**2025/0121 - GATEWAY 36 PLOT 7, LAND SOUTH OF DEARNE VALLEY PARKWAY HOYLAND
RESPONSE TO DESIGN, LANDSCAPE AND VISUAL IMPACT COMMENTS**

Thank you for your email of 30 October 2025 including the comments of your urban design officer and landscape consultant on the above reserved matters application for an employment building (amended proposal).

**Site Sectional Elevations - rev. A**

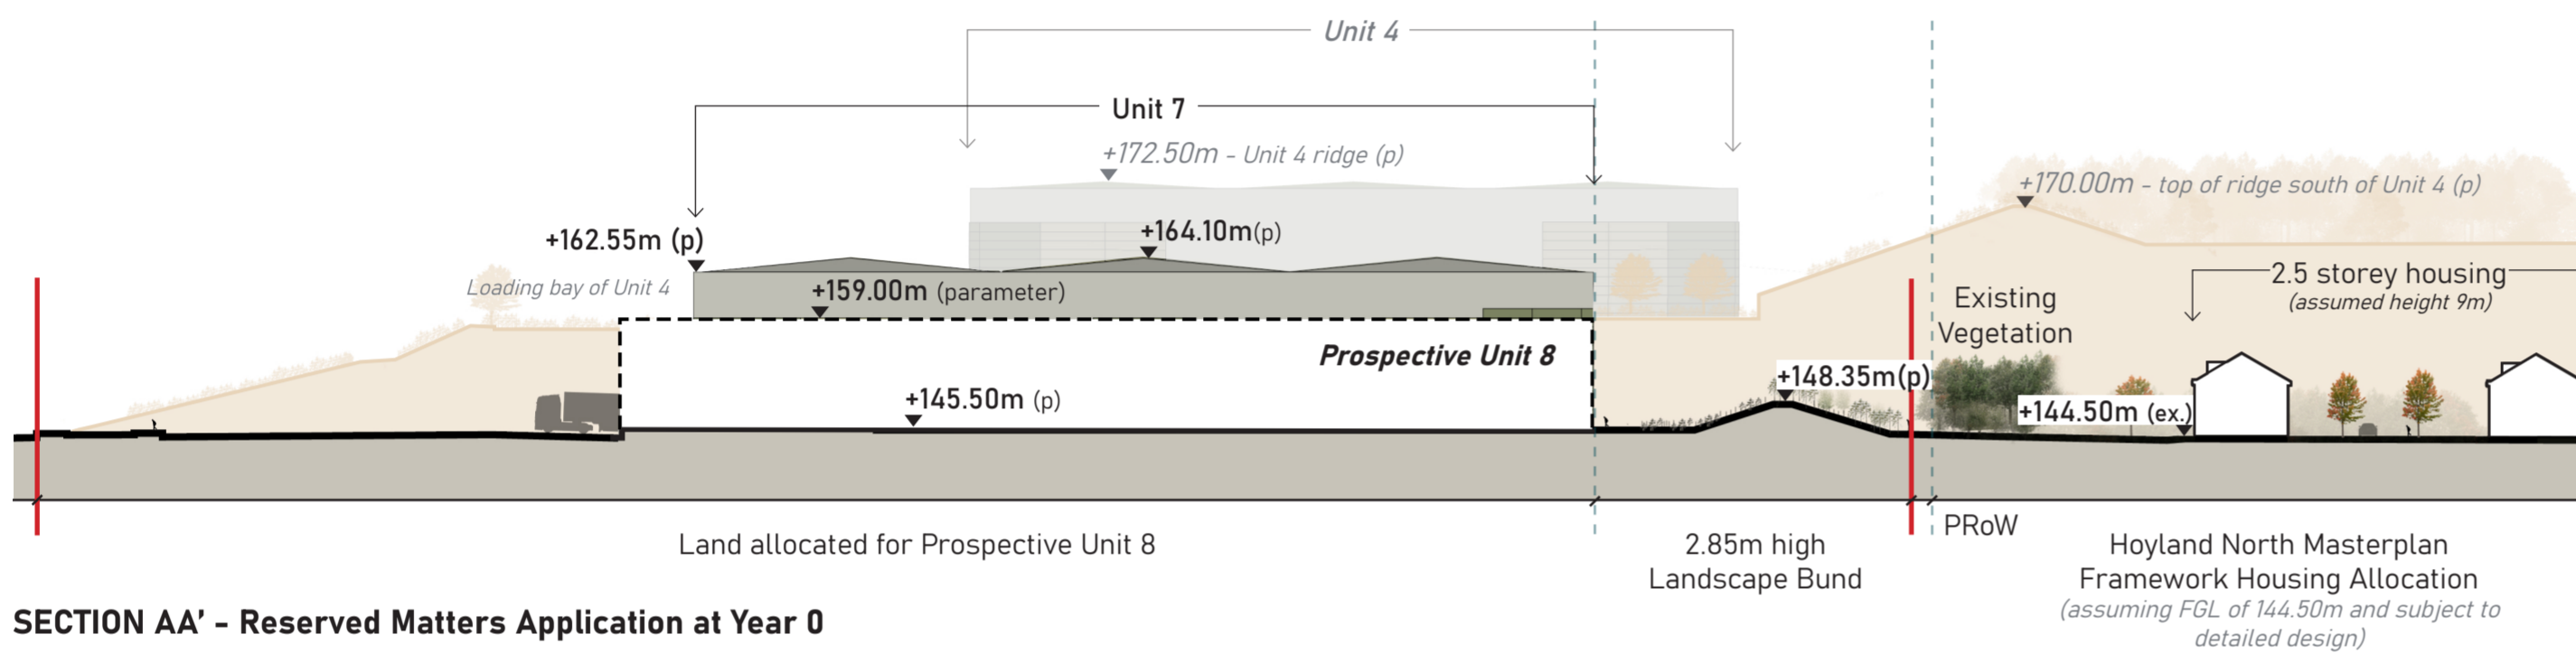
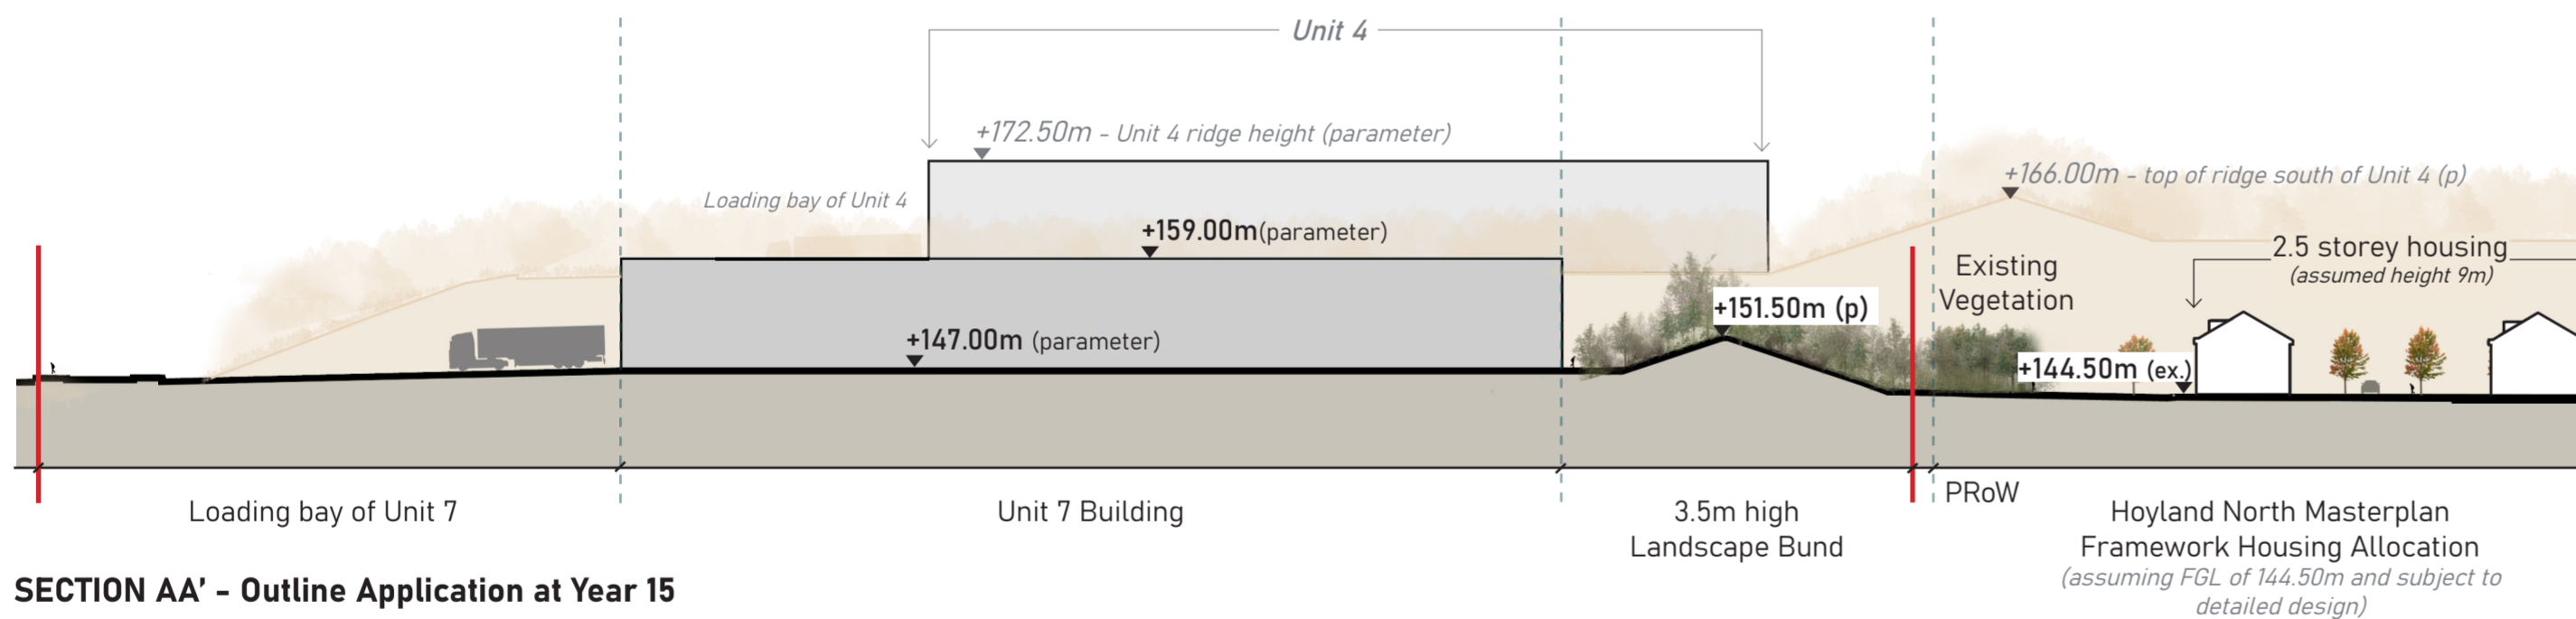
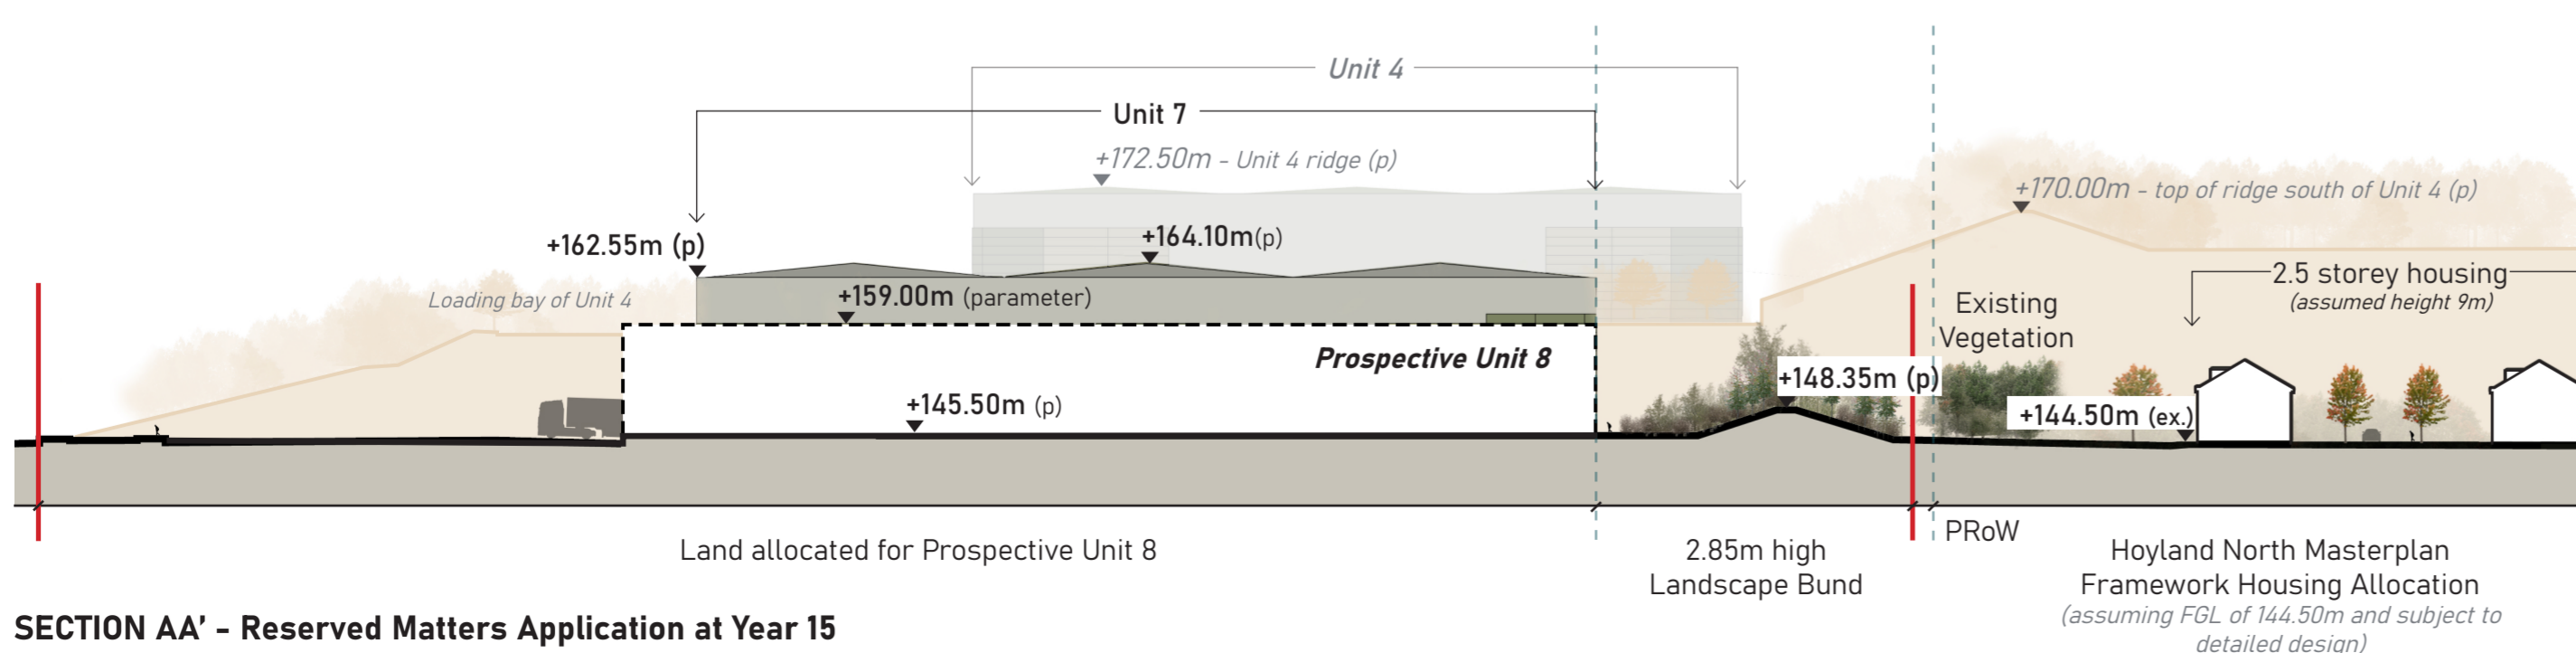
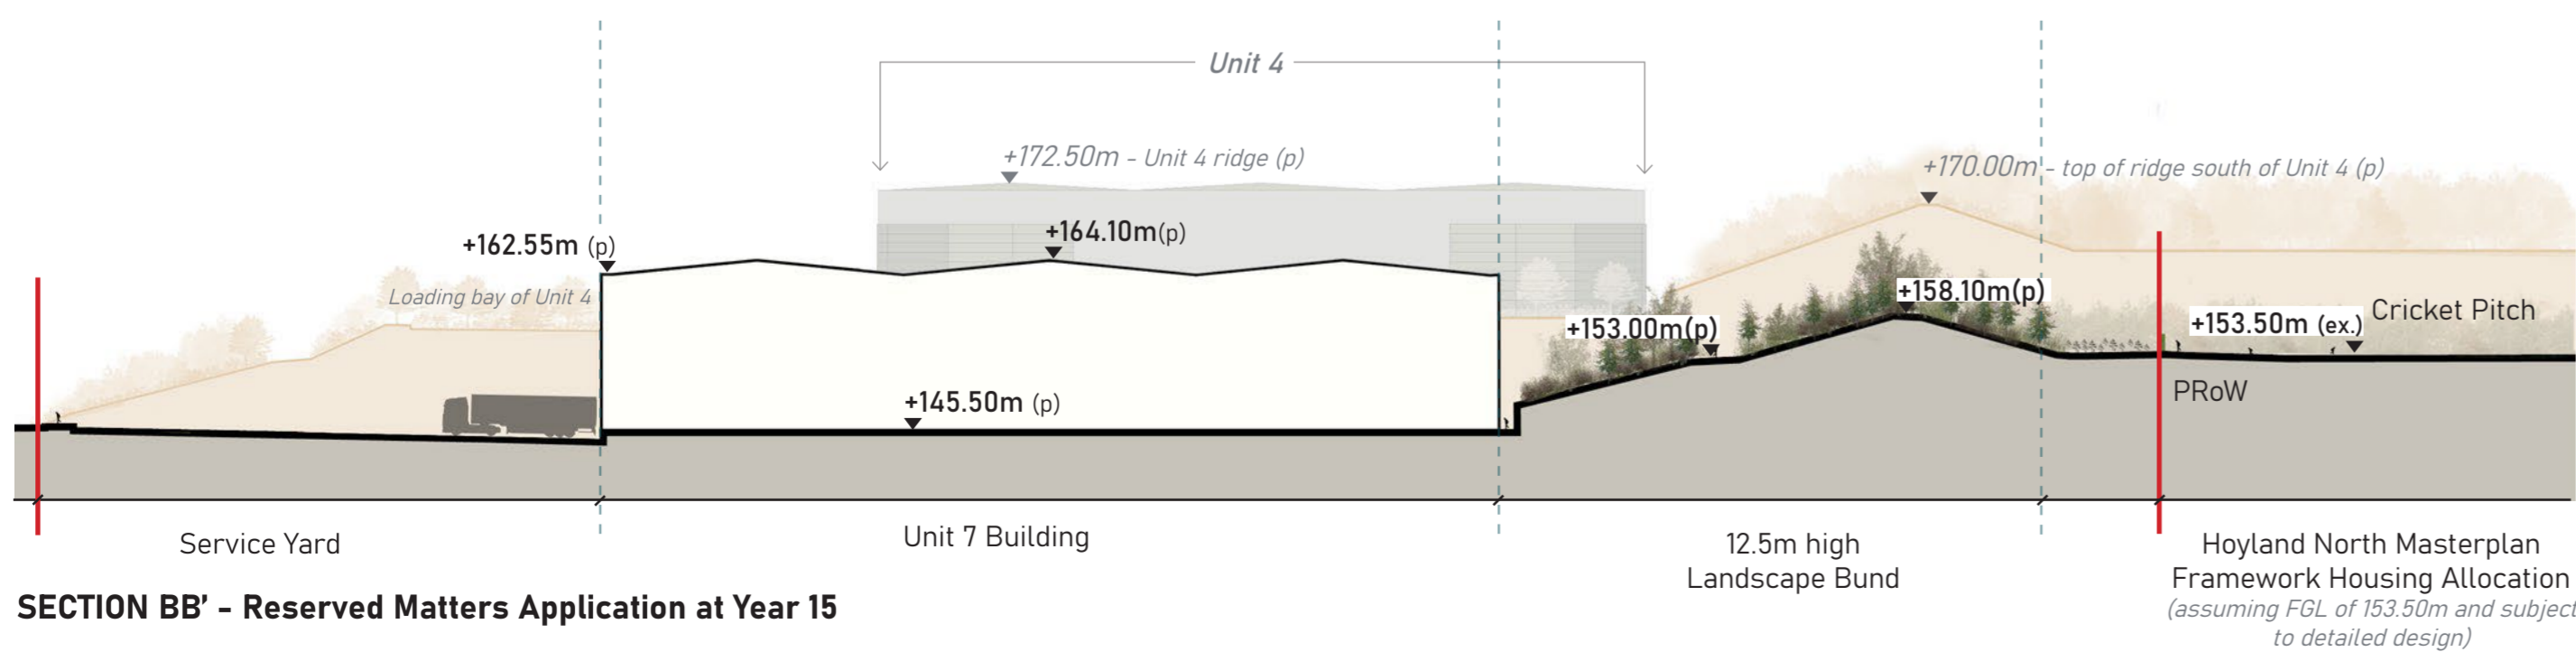
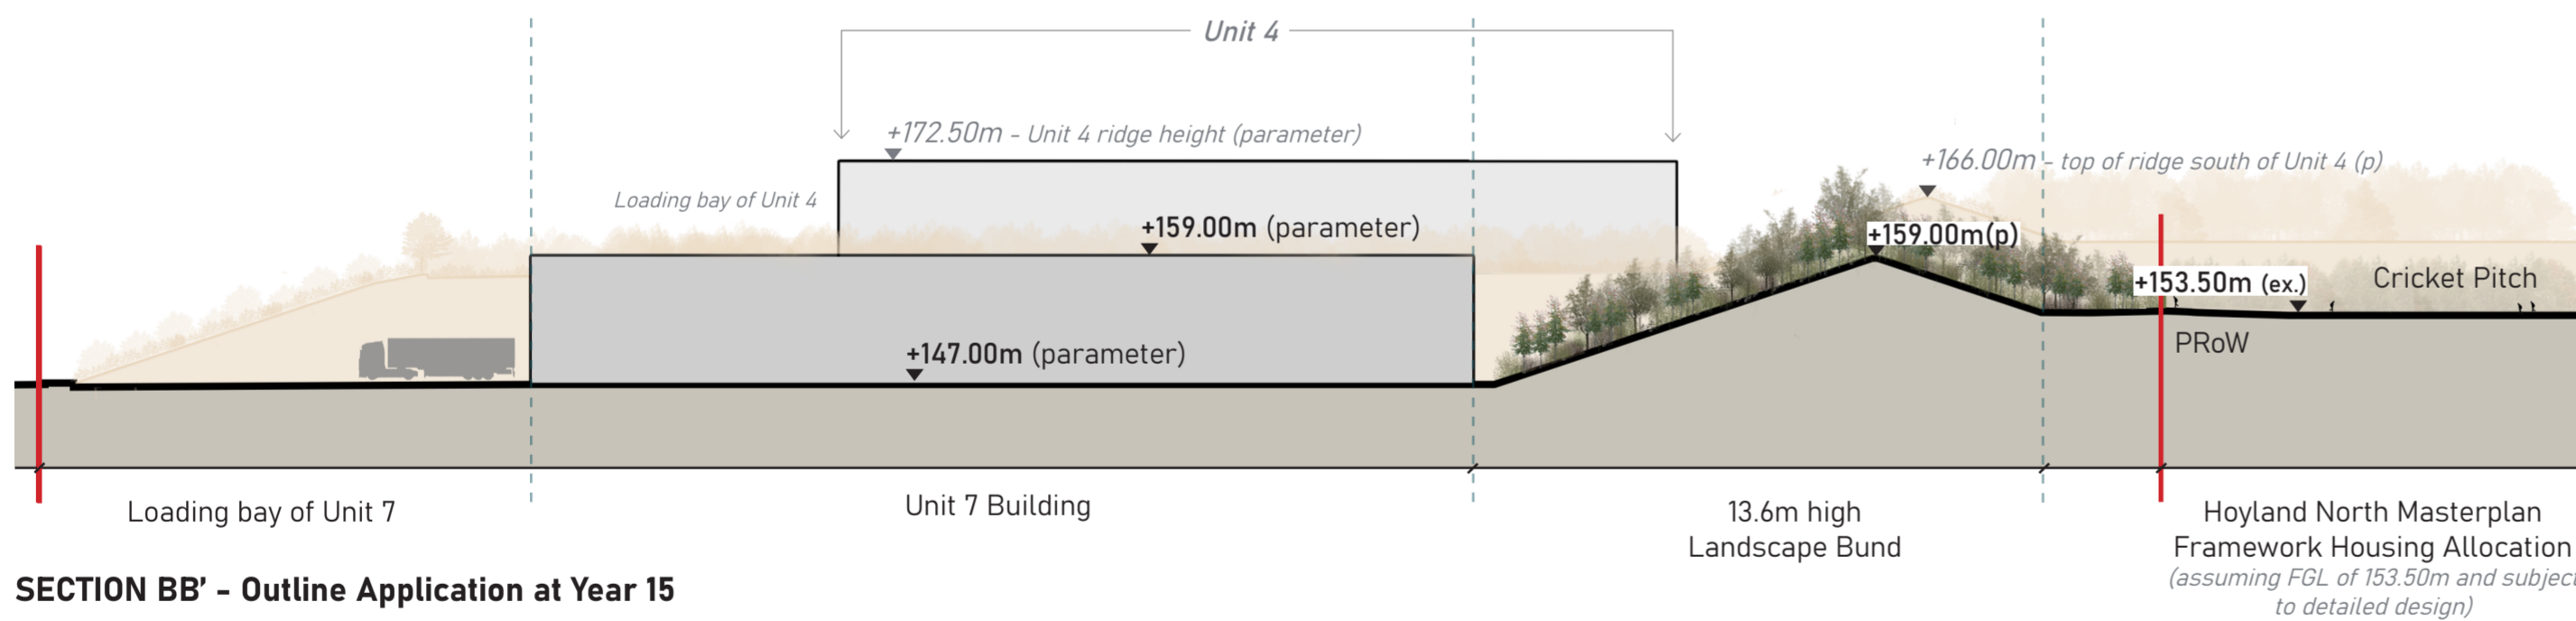
As requested, we respond to the comments of the Urban Design Officer including those relating to any effect of the development on the adjacent land allocated for housing development.

We note that these section lines do not capture the adjacent housing allocation site, but also that the details of the housing scheme are not known (i.e. ground levels, retained/proposed landscape buffers, arrangement and orientation of dwellings and open space).

Our landscape architect has therefore prepared extended and supplemented versions of these section lines which are appended to this note and explained below.

Section BB corresponds to Section 2 and shows the relationship between the proposed Unit 7 building and the adjacent housing allocation site in the location of the open space (cricket pitch) as shown on the Hoyland North Masterplan Framework drawing.

Section AA corresponds to Section 1 and shows the relationship between the prospective Unit 8 building and the adjacent housing allocation site in the location of the area identified for housing as shown on the Hoyland North Masterplan Framework drawing. This shows a distance of approximately 65m from the building to the position of a house on the adjacent site (allowing for back garden to site boundary).

However, it is crucial to note that there is no proposal for the housing development to confirm the ground levels and position of houses. The indication presented is therefore based on reasonable assumed ground levels and siting, intended to present a 'worst case' scenario.

In both cases, the same section line is presented with outline parameter data and the reserved matters proposal, both at Year 0 and Year 15. This allows comparison with the original approved extent and shows the effect of mature landscape planting.

Whilst there may be visibility of the employment development from the housing allocation site (which is not unusual), taken with the landscape bund and planting proposed within the employment site (and notwithstanding landscape planting that may reasonably be expected in the housing site), this is not considered to prejudice the setting of future housing or constitute a harmful impact.
